Arun District Council
Planning Department
Maltravers Road
Littlehampton
West Sussex
BN17 5LF

I refer to Planning Reference AL 107/16.

Thank you for sending through the consultation responses received in regards to our application. I will address the points raised by residents and consultees below.

Aaron Wright
Planning Manager
David Wilson Homes

Drg No: 160104/MC Rev:

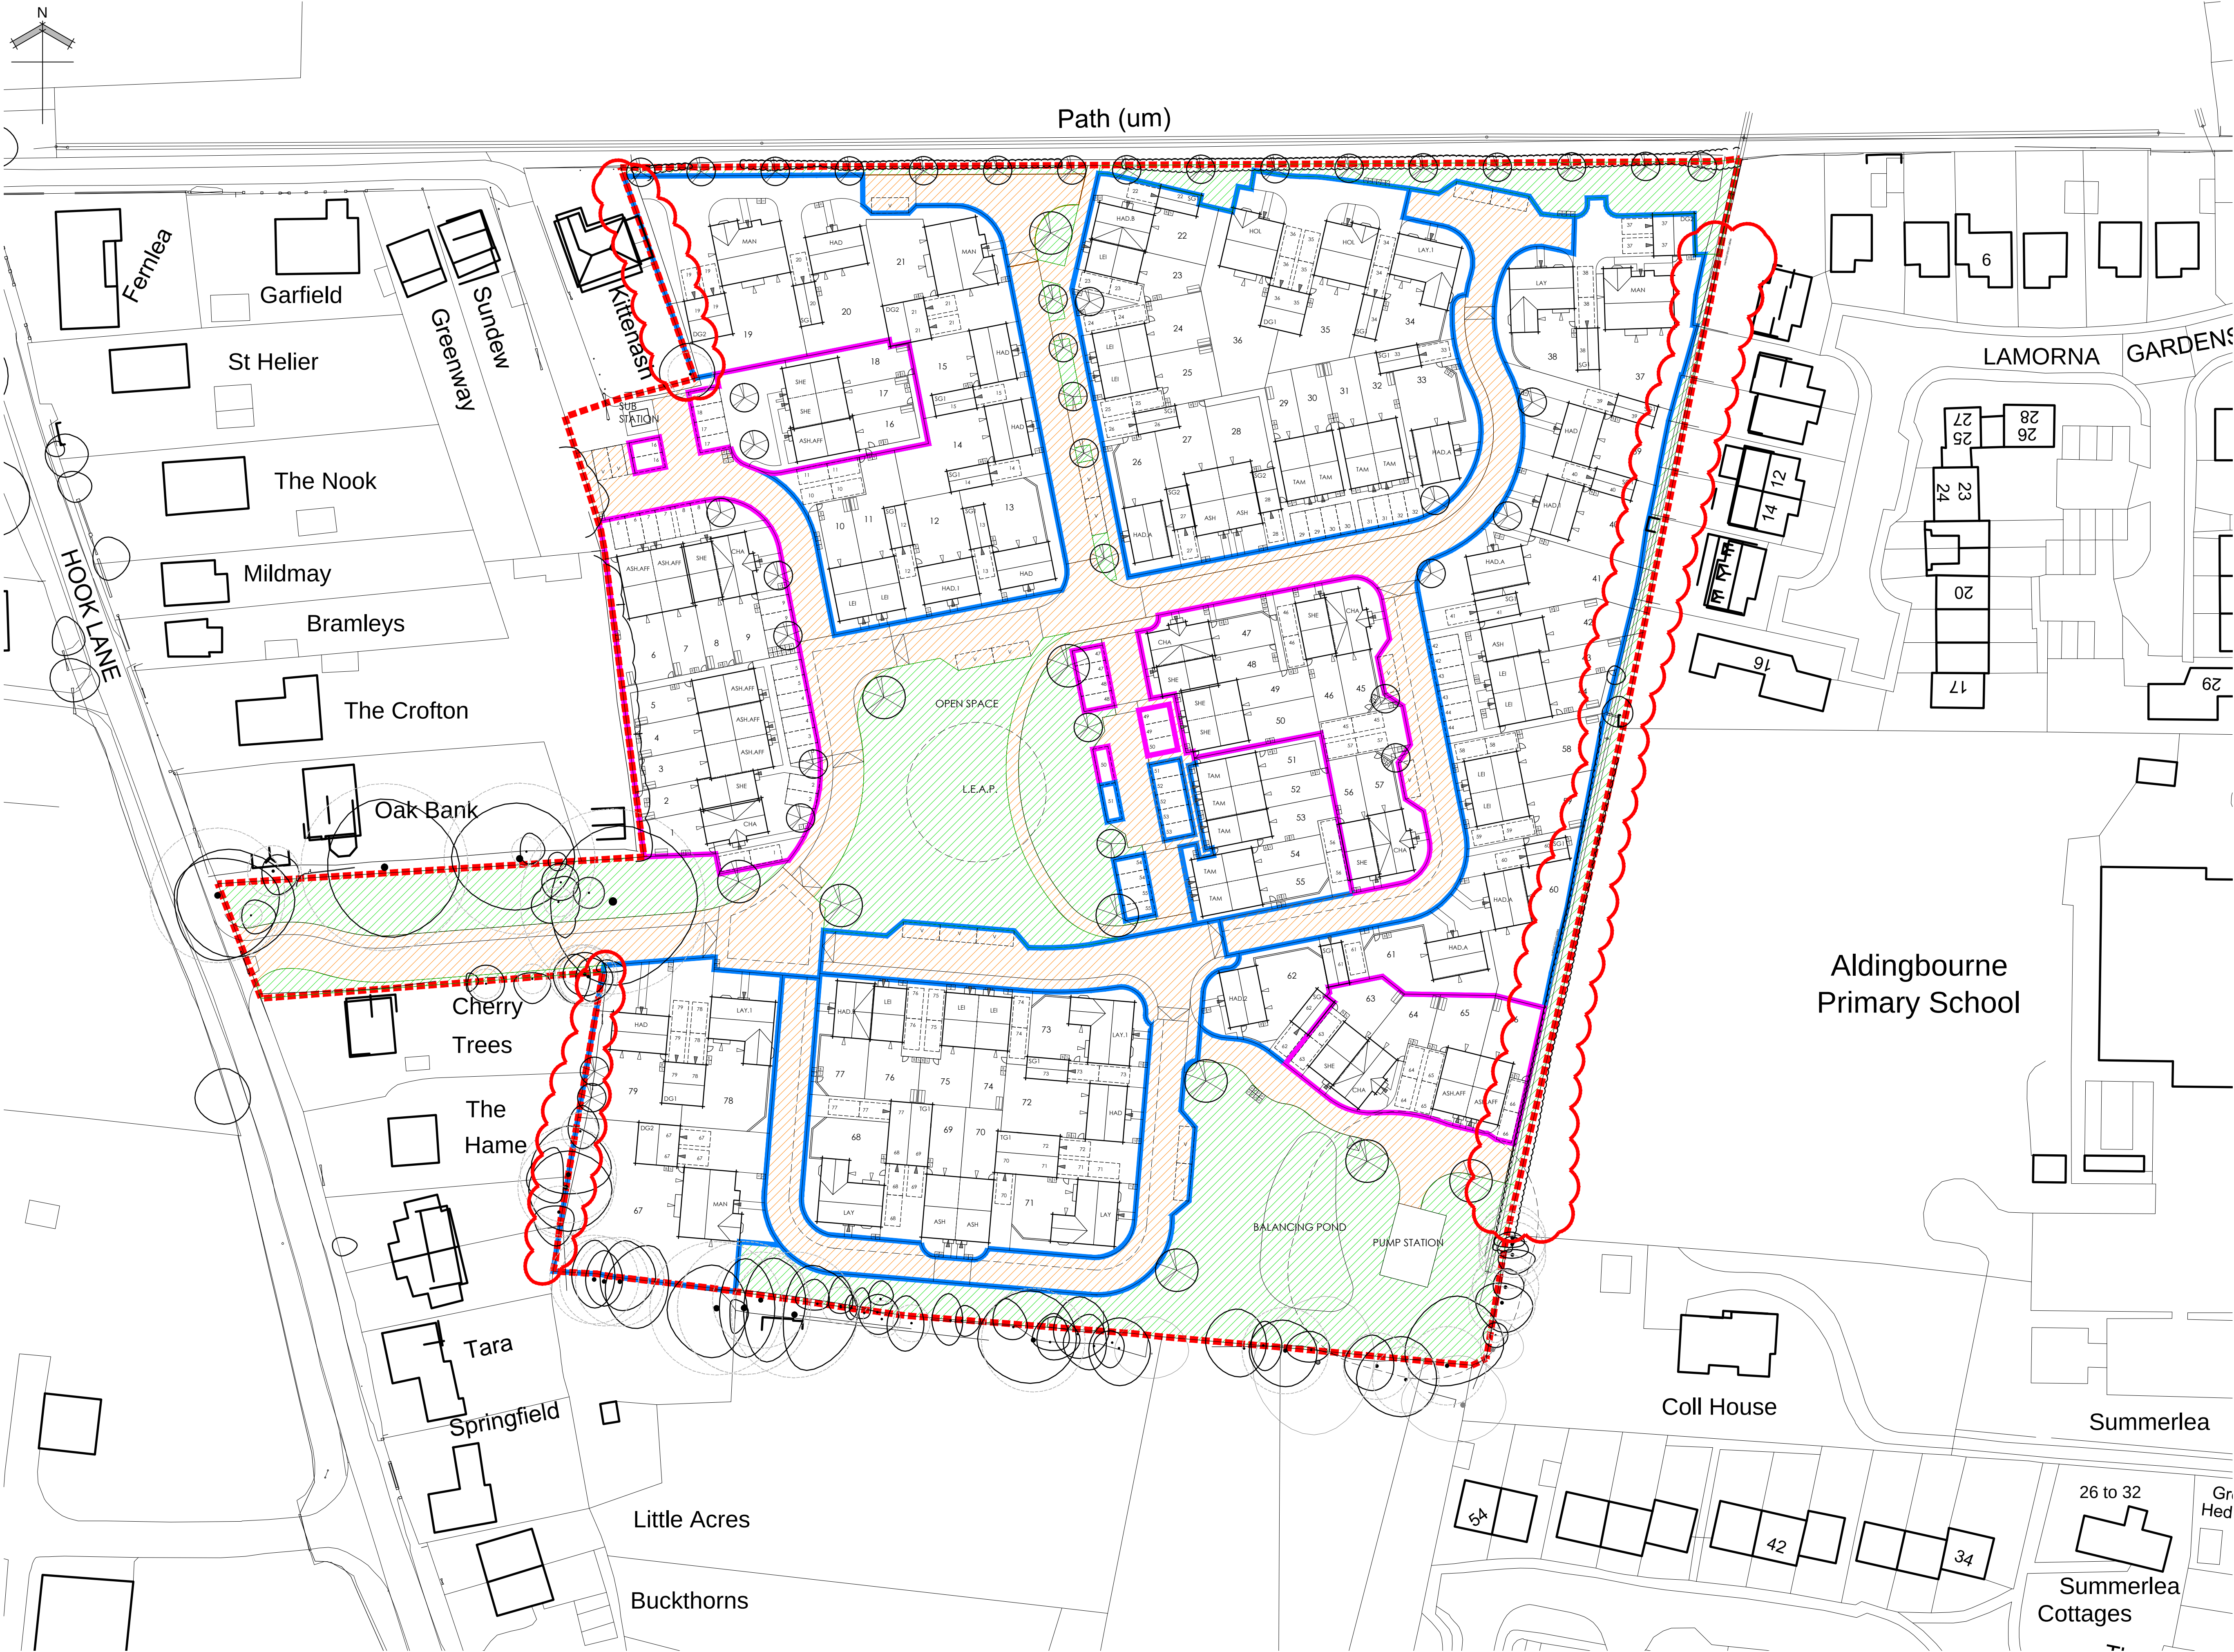
As stated in paragraph 3.7 of the Reserved Matters Transport Assessment, all internal site roads are to remain private. This matter is also addressed in the highways comments, where the 'Management Company Plan, drawing reference 160104/MC, is stated which demonstrates that the internal layout is to be kept private.

BDWS20440-03

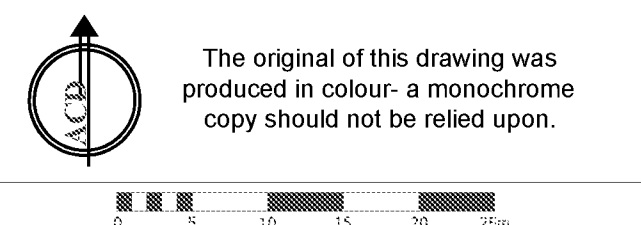
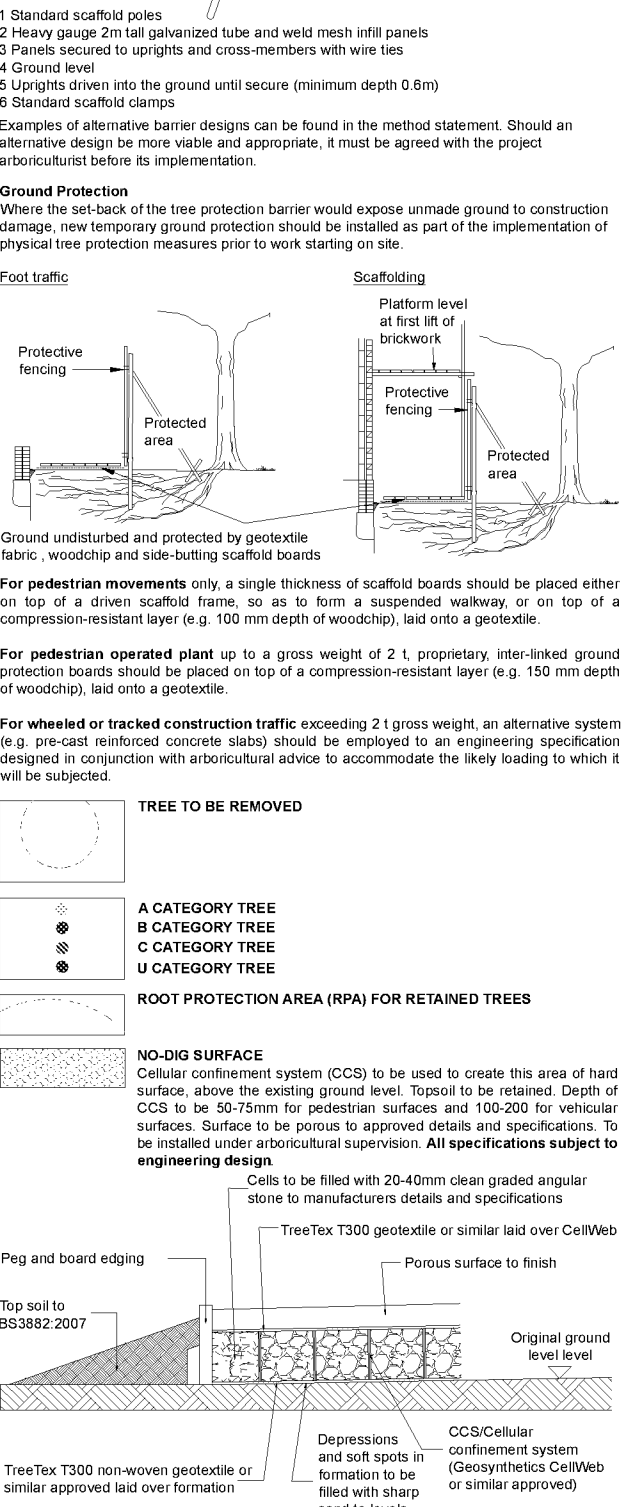
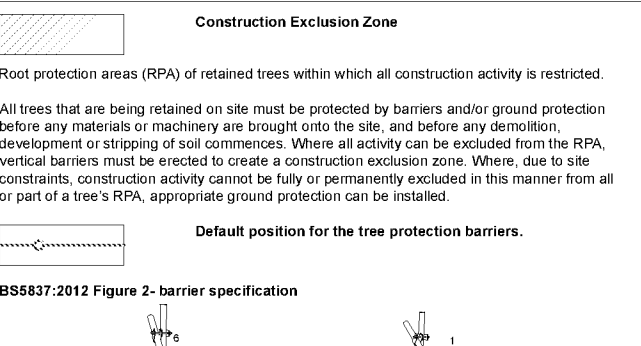
-At the bottom of the garden a eucalyptus has not been included in the tree survey – and so protection has been given to the roots.

Our response: A revised Tree Protection Plan (Rev 3A) has been provided showing additional root protection areas around trees and hedgerows.
